**PAVEMENT DESIGN REPORT  
VOLLMER ROAD NORTH  
EL PASO COUNTY, COLORADO**

Prepared for:  
**Classic Communities  
2138 Flying Horse Club North  
Colorado Springs, Colorado 80921**

December 22, 2023

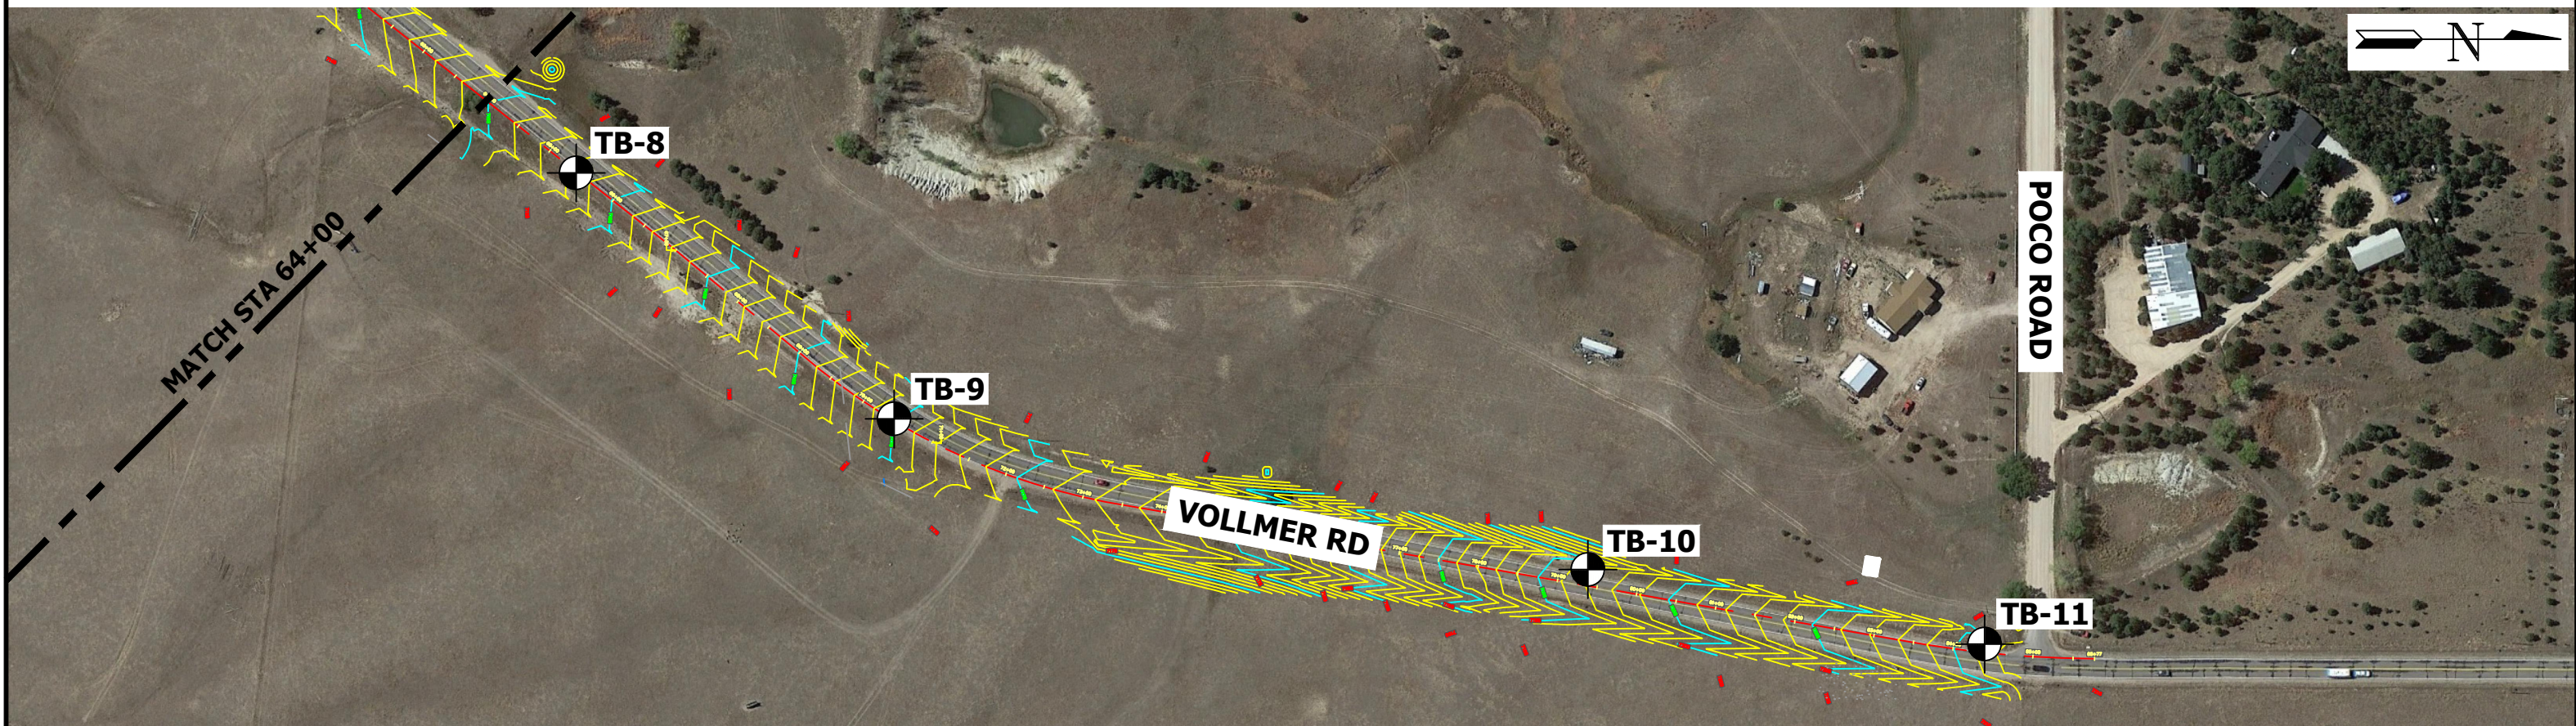
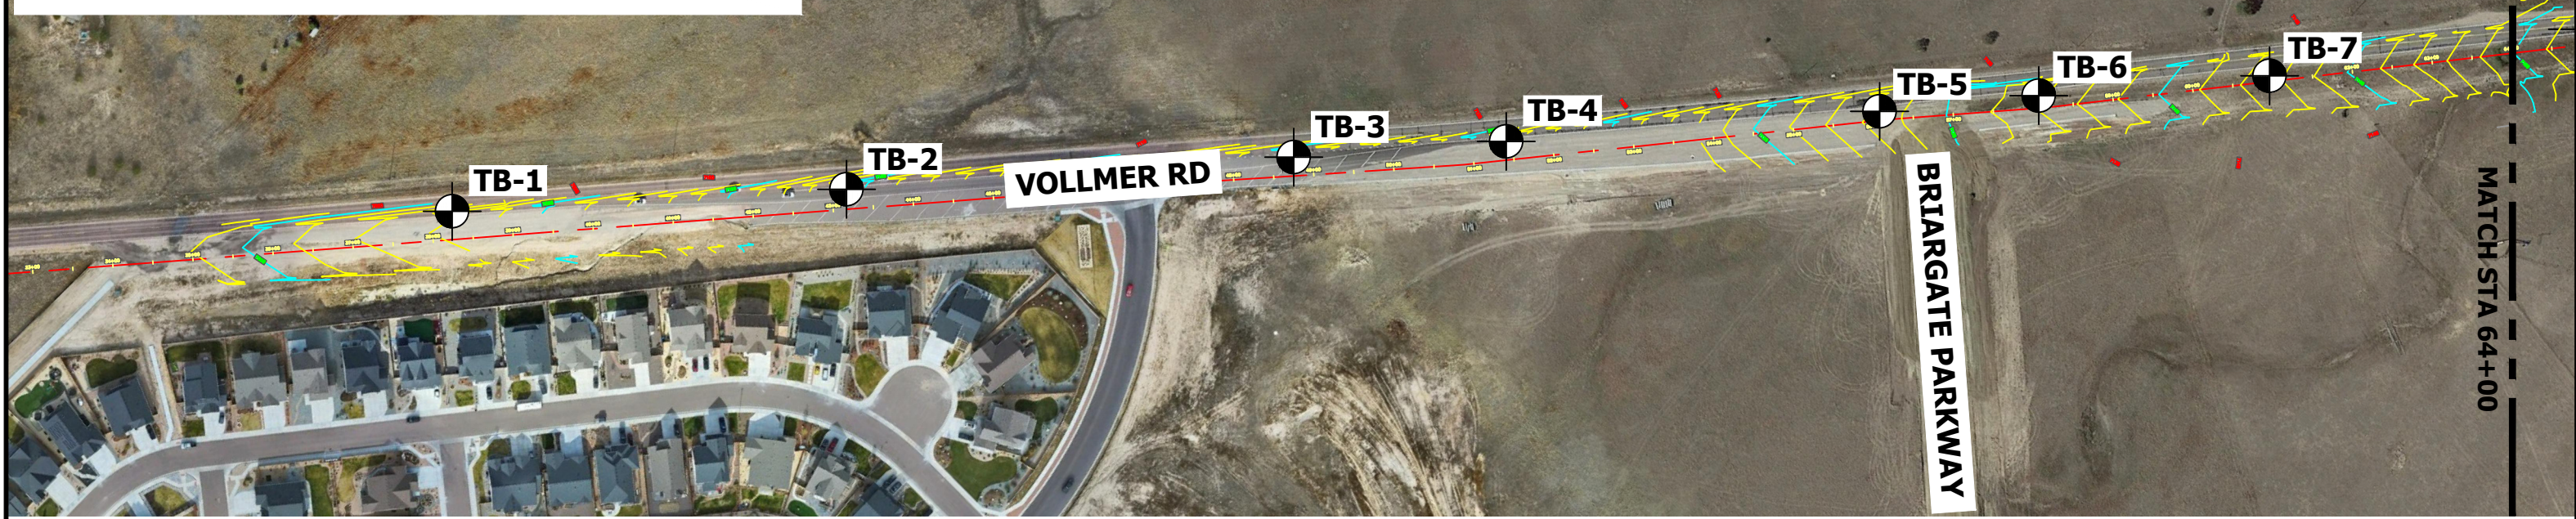
Create separate exploration plan for bore locations

Include legend for pavement alternatives

Remove line work from this area.
